CITY OF ALBUQUERQUE

March 6, 2006

**Re: Tract A of El Cambino Plaza Addition, 511 Bridge Blvd., Traffic
Circulation Layout, Architect's Stamp dated XX-XX-XX (L14-D55)**

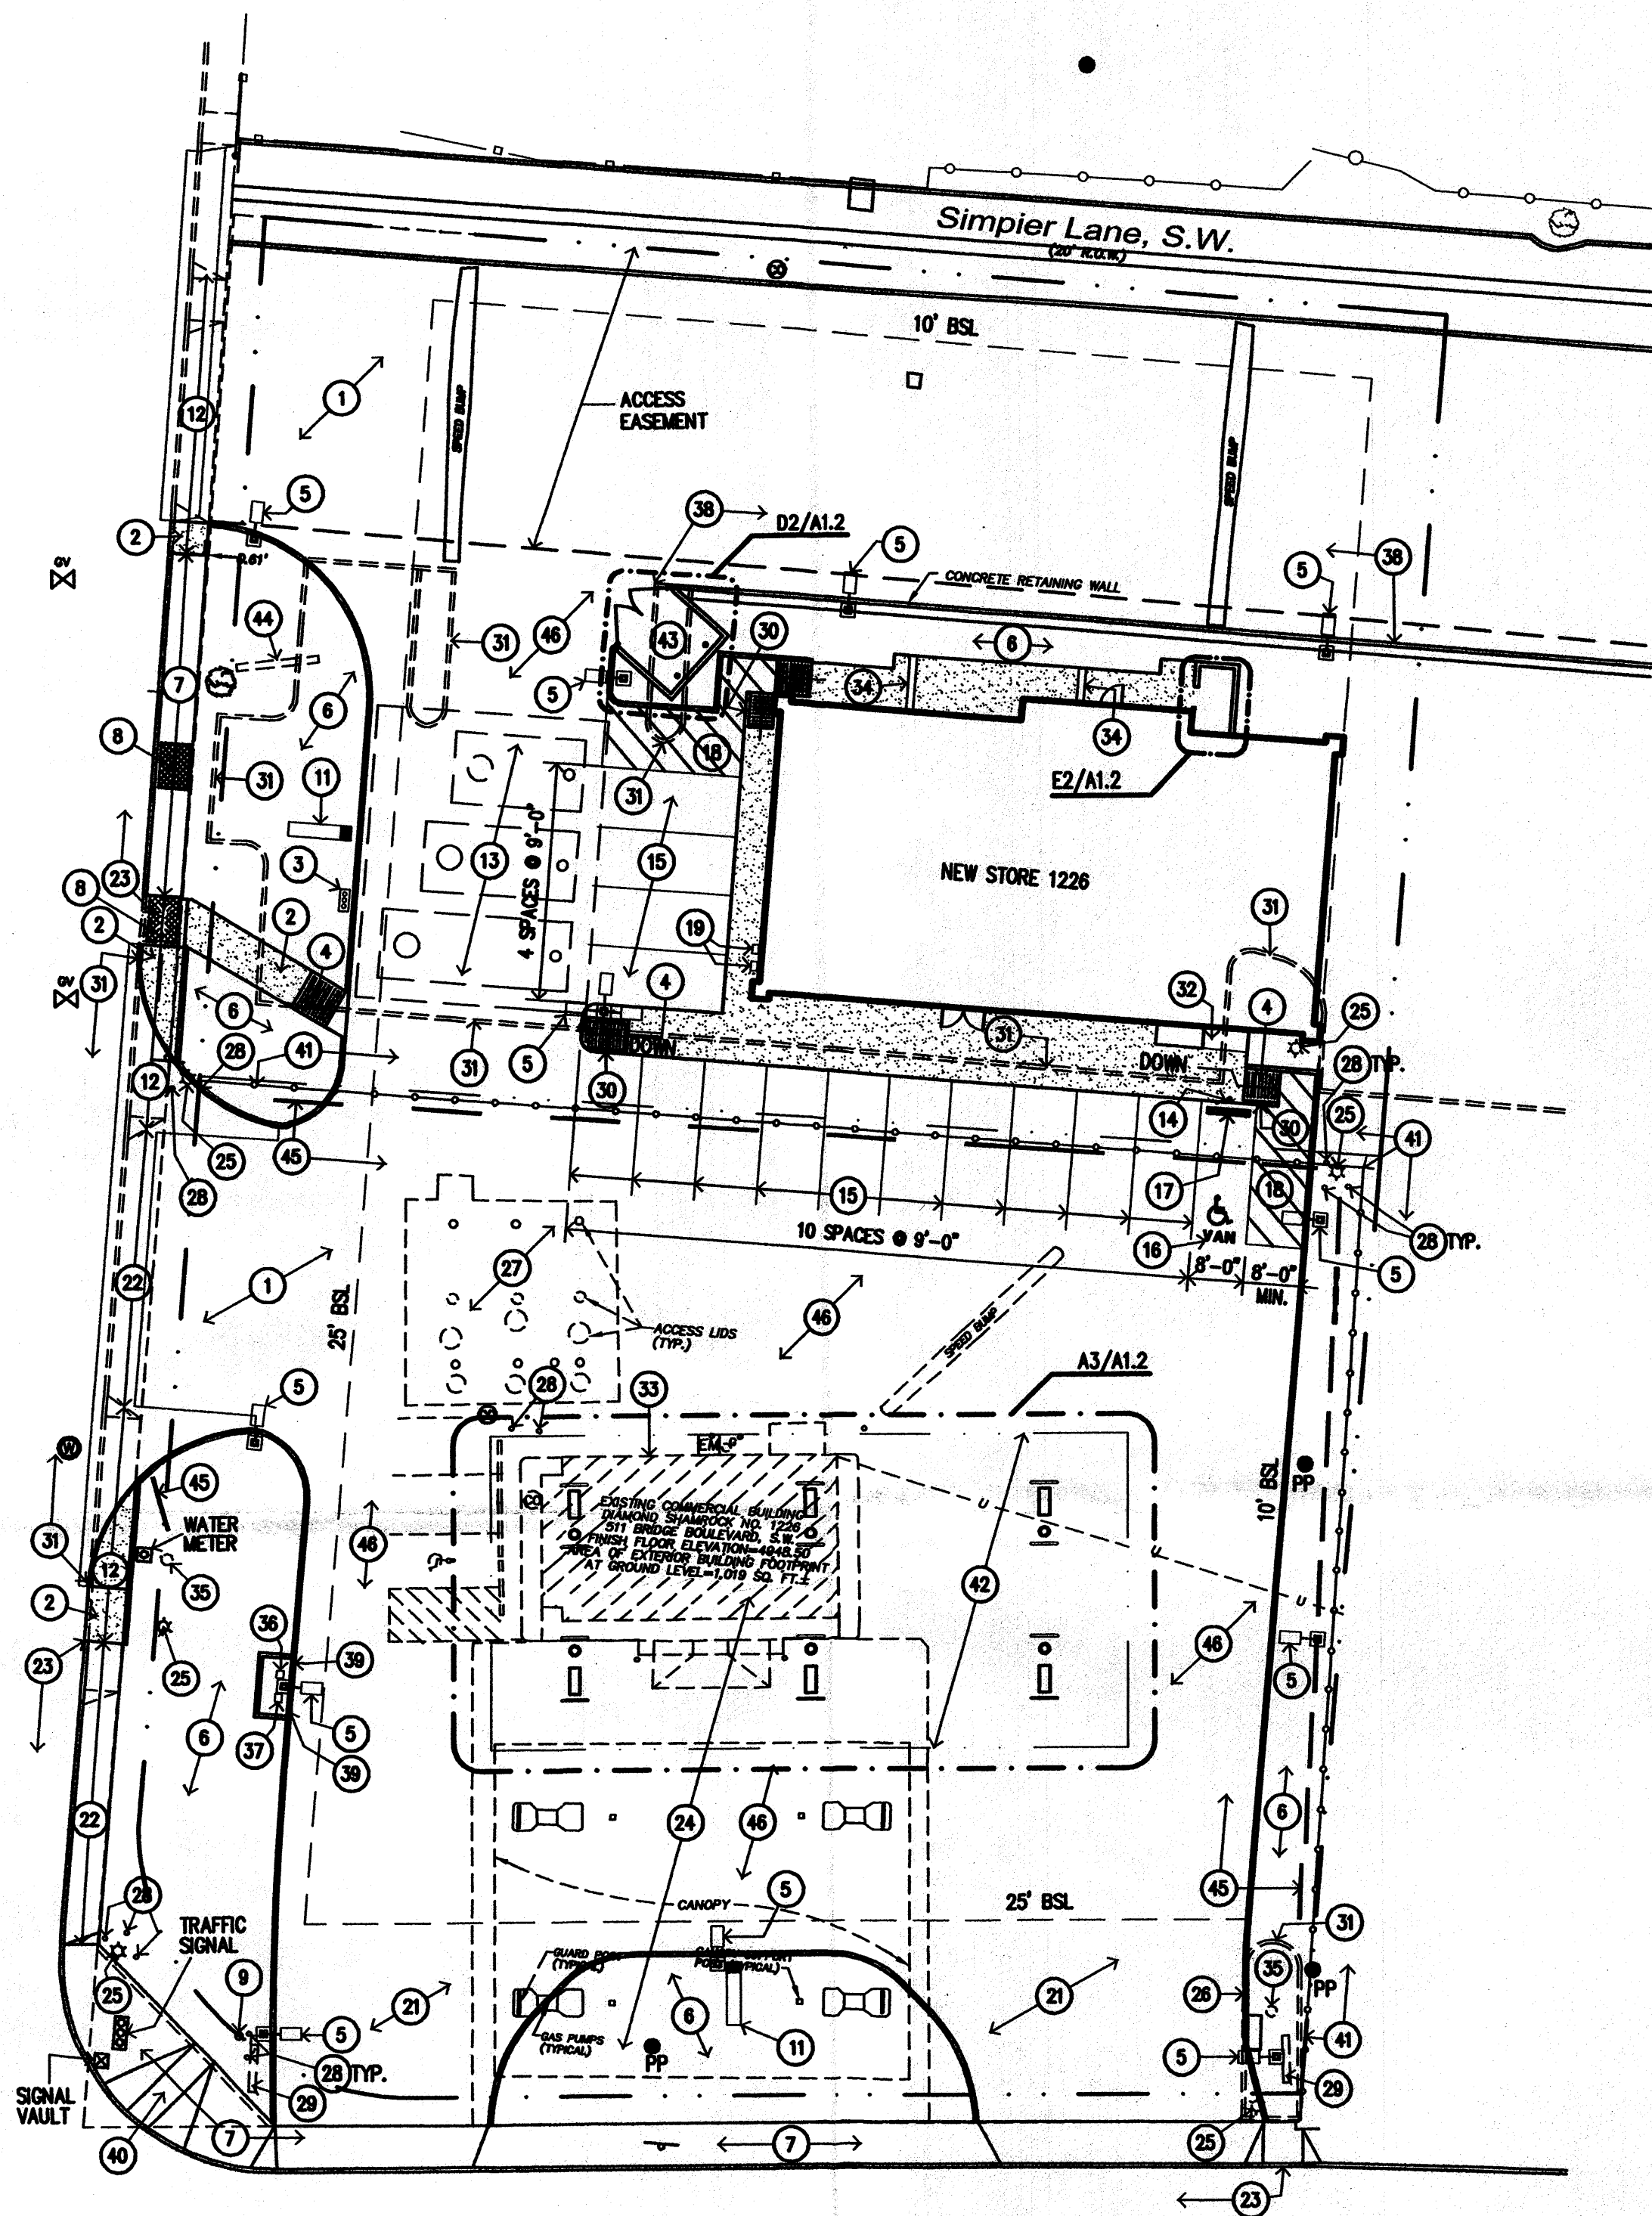
1. Please, refer to all appropriate City Standards; the drawing number should be included in this reference; these numbers refer to the curb & gutters, drive-pads, and sidewalks.
2. Provide the width for all sidewalks. (proposed and existing)
3. Include the dimensions, (lengths and widths), of the parking stalls.
4. Provide parking calculations.
5. Provide a vicinity map of the project.
6. Include the widths of entrances. (proposed and existing)
7. Will a cross lot access easement be required?
8. Parking will need to be contained on-site; if this not possible the site will need to be re-plated.
9. A stamped, dated, and signed plan will need to be submitted for next review.
